**From:** Michael Lyons [REDACTED]  
**Sent:** 29 April 2021 22:04  
**To:** Nicola Moore  
**Subject:** BN/48/21/CLP  
**Attachments:** Pippin Cottage Block Plan.pdf; Pippin Cottage Elevations.pdf; Pippin Cottage Floor Plan.pdf

Pippin Cottage  
Highground Lane  
Barnham  
Bognor Regis  
West Sussex  
PO22 0BT

Pippin Cottage

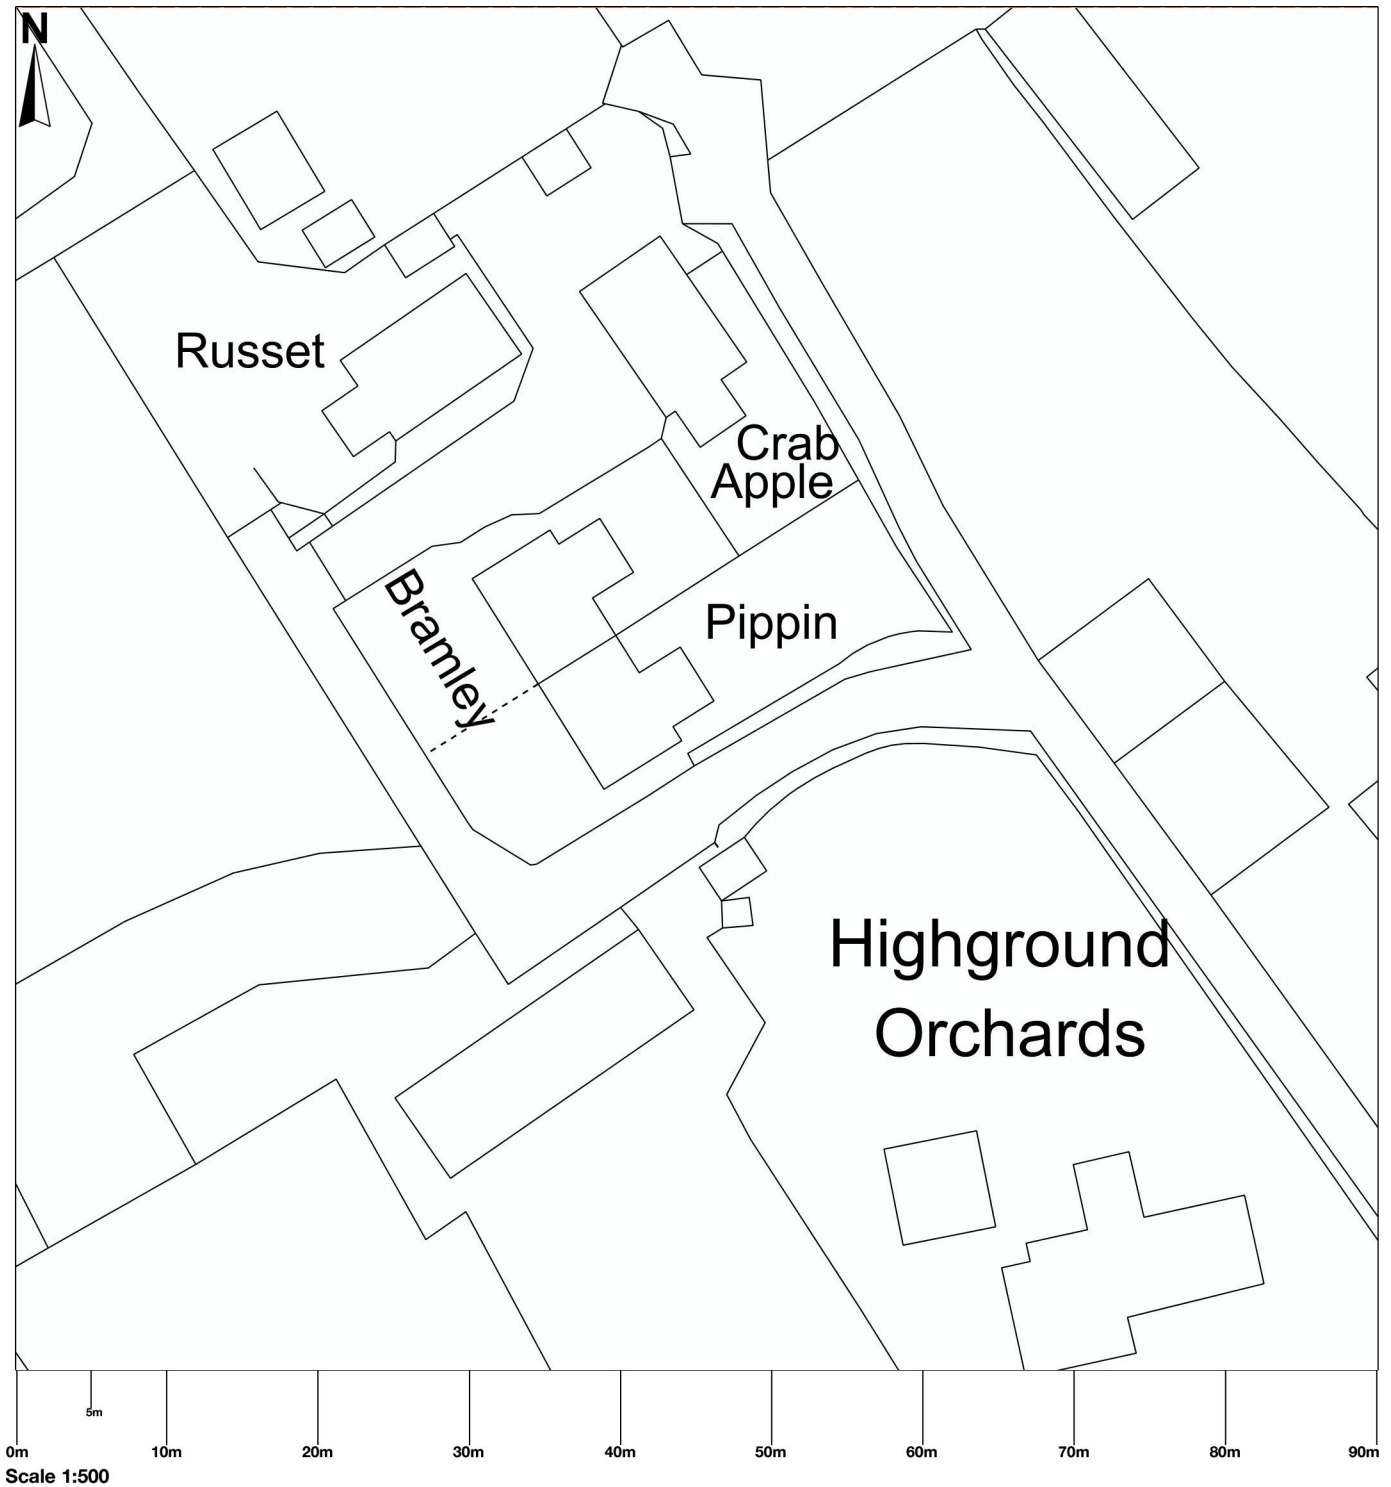
Please provide the measurements to boundaries. The measurements of the proposed building do not match those on application form. Please check, amend accordingly and re submit.  
Measurements to boundaries included in floor plan (PDF attached). Blank block plan PDF attached.

NOT TO SCALE

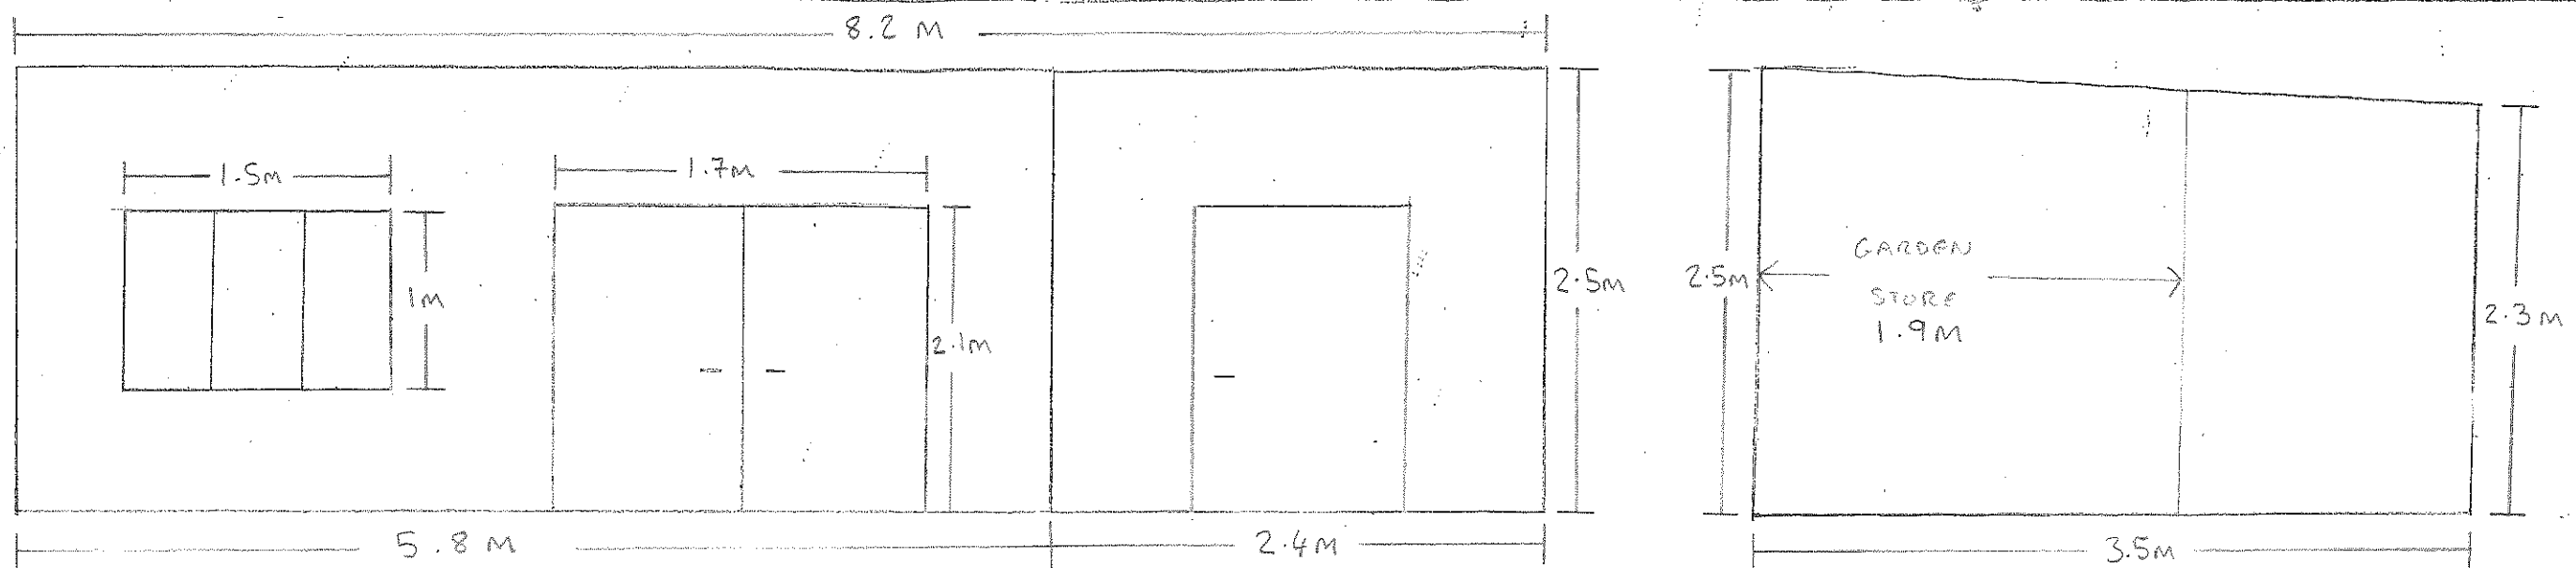
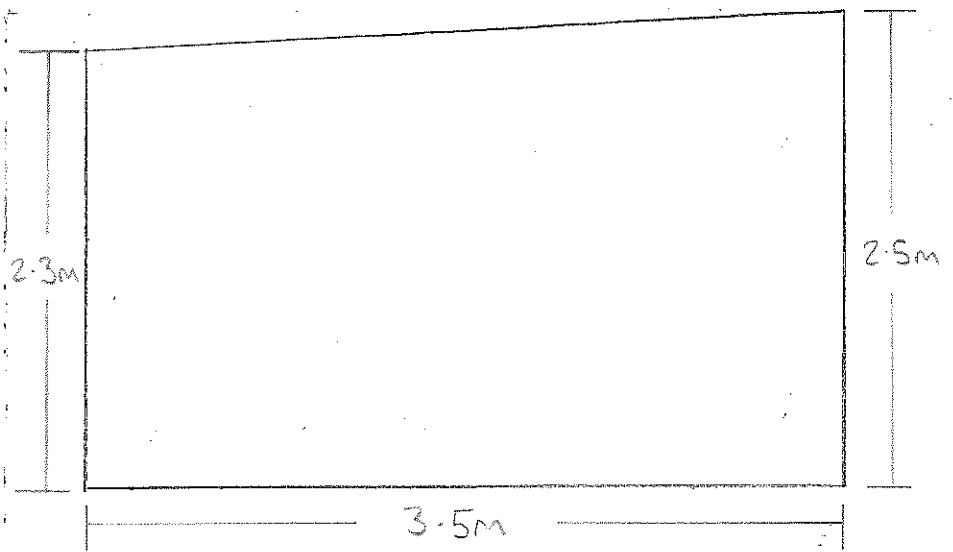
We are unable to scale plans at 1:40, please either remove the scale and add clear dimensions, or scale at 1:50 or 1:100.  
Elevation drawing amended, scale removed and replaced with dimensions.
